## **Coal Free Southern Highlands Inc.**

2 October 2018

### **CFSH Inc comments regarding Response to Submissions by Hume Coal Pty Ltd, SSD 15-7172**

Figure 1 - Interburden thickness (after Coffey 2016a, Figure 4.3)

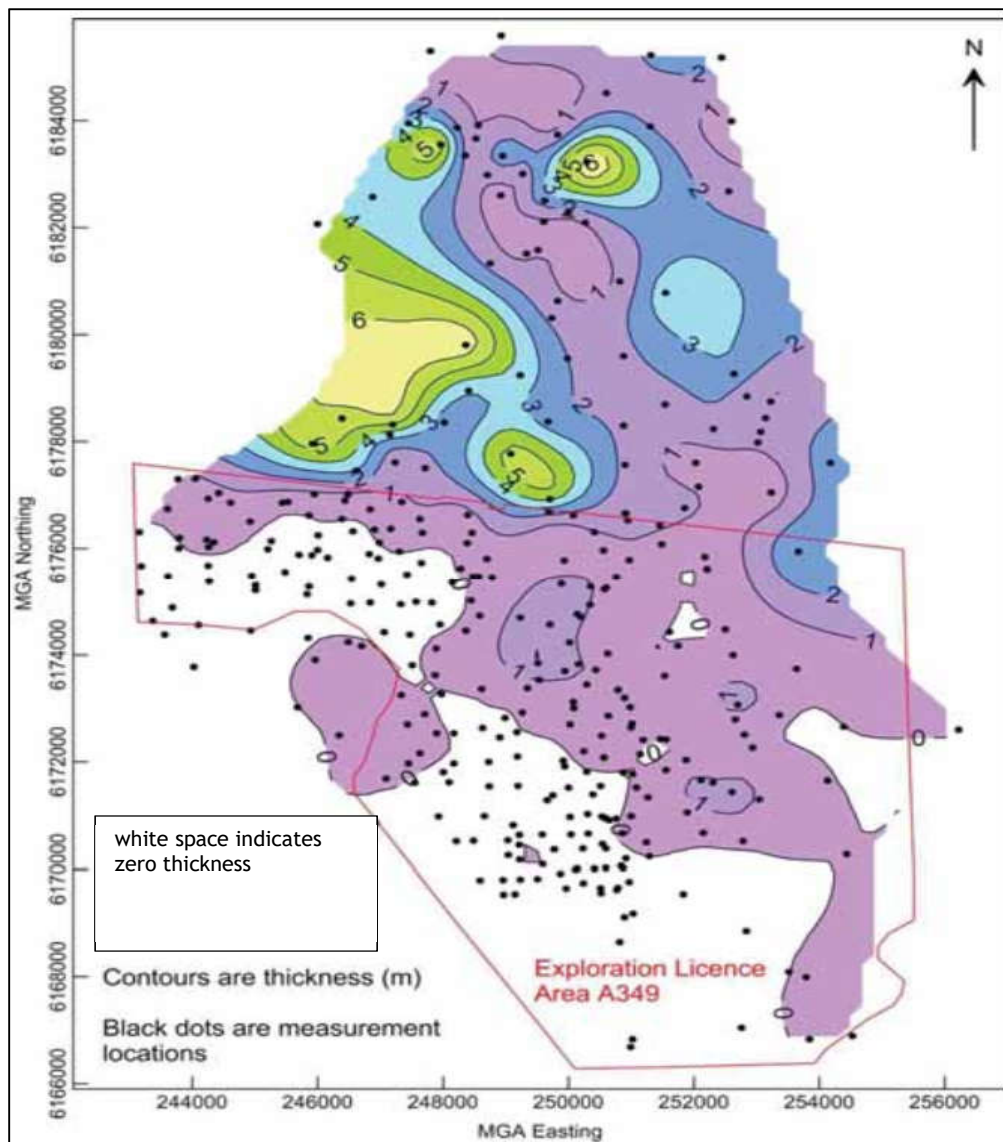
4. Our understanding from a recent meeting with **DoI Water is that it has not been provided with the detailed geological data**. They are relying on an assurance from Hume that the geological data that forms the basis of the model has been correctly interpreted. It is difficult to understand how this agency could do their job effectively without direct access to this information.
5. The **confusion over the role of the 'interburden' in the conceptual geological model remains an issue**. In the EIS this layer, Layer 8, is said to average 4 metres thickness over the mine area, with a minimum thickness of 0.1 metres in any model cell. The data in the EIS refutes this analysis.

**The RTS attempts to redefine this situation**. It now describes 'interburden' as being the material from the bottom of the Hawkesbury Sandstone to the top of working section of the coal seam. A new chart of this redefined 'interburden' is included in the RTS. In substantial parts of the mine area, the thickness of this redefined 'interburden' is in the range 1-2 metres and, by inspection, the average thickness of this material is far less than average 8 metres recorded in the EIS to which is said to be largely comparable.
